PLANNING AMENDMENT

Application No. H08/0333/03/A1
Date Registered 29 MAY 2003
Case Officer pu

Proposed Alterations & Extension
To Existing Bungalow.

Amendment: Reduce utility room, alterations to fenestration & minor
internal alterations (Dwg.No.3126-001C)

Client: Mr & Mrs P Thorold
Project: Proposed Alterations & Extension
Drawing: Plan As Proposed
Drawn: J.C.P. Scale: 1:50 Date: 28.02.03 Checked: Approved:
DWG. No. 3126 - 001 ISSUE: C

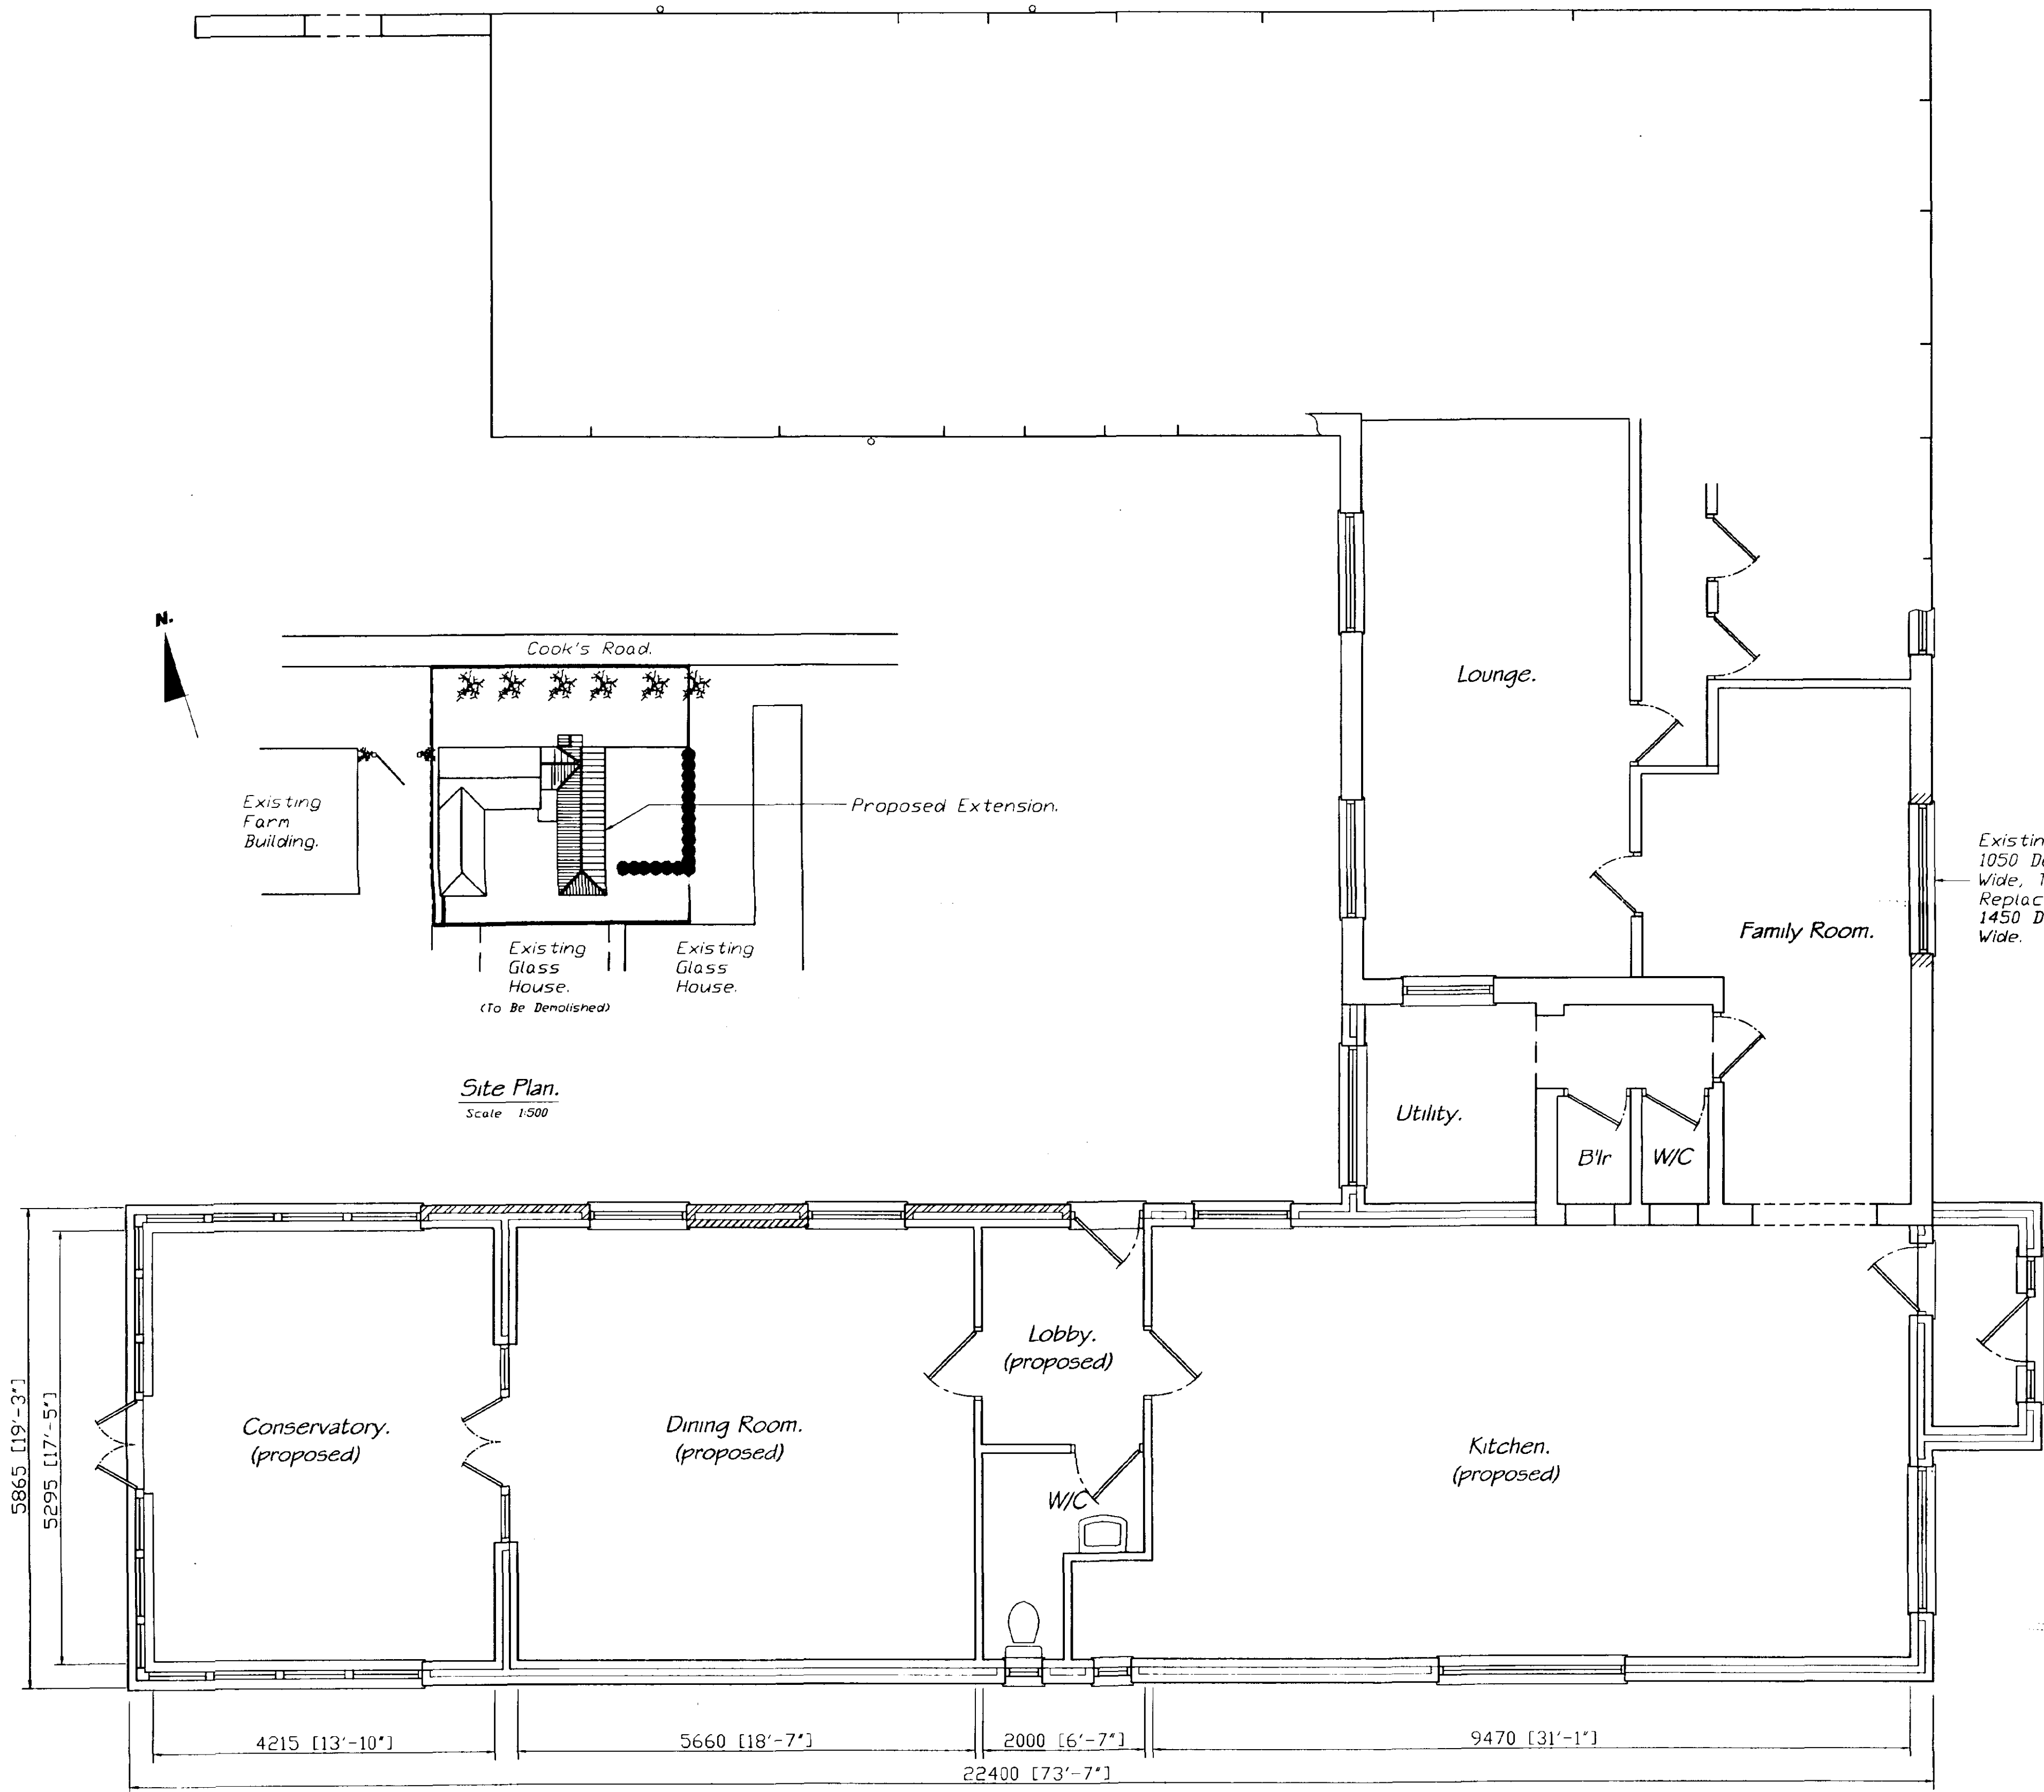
Size of utility room reduced.
Window removed From Dining Room.
One window taken out of Kitchen.
Corridor, Lobby and W/C altered.
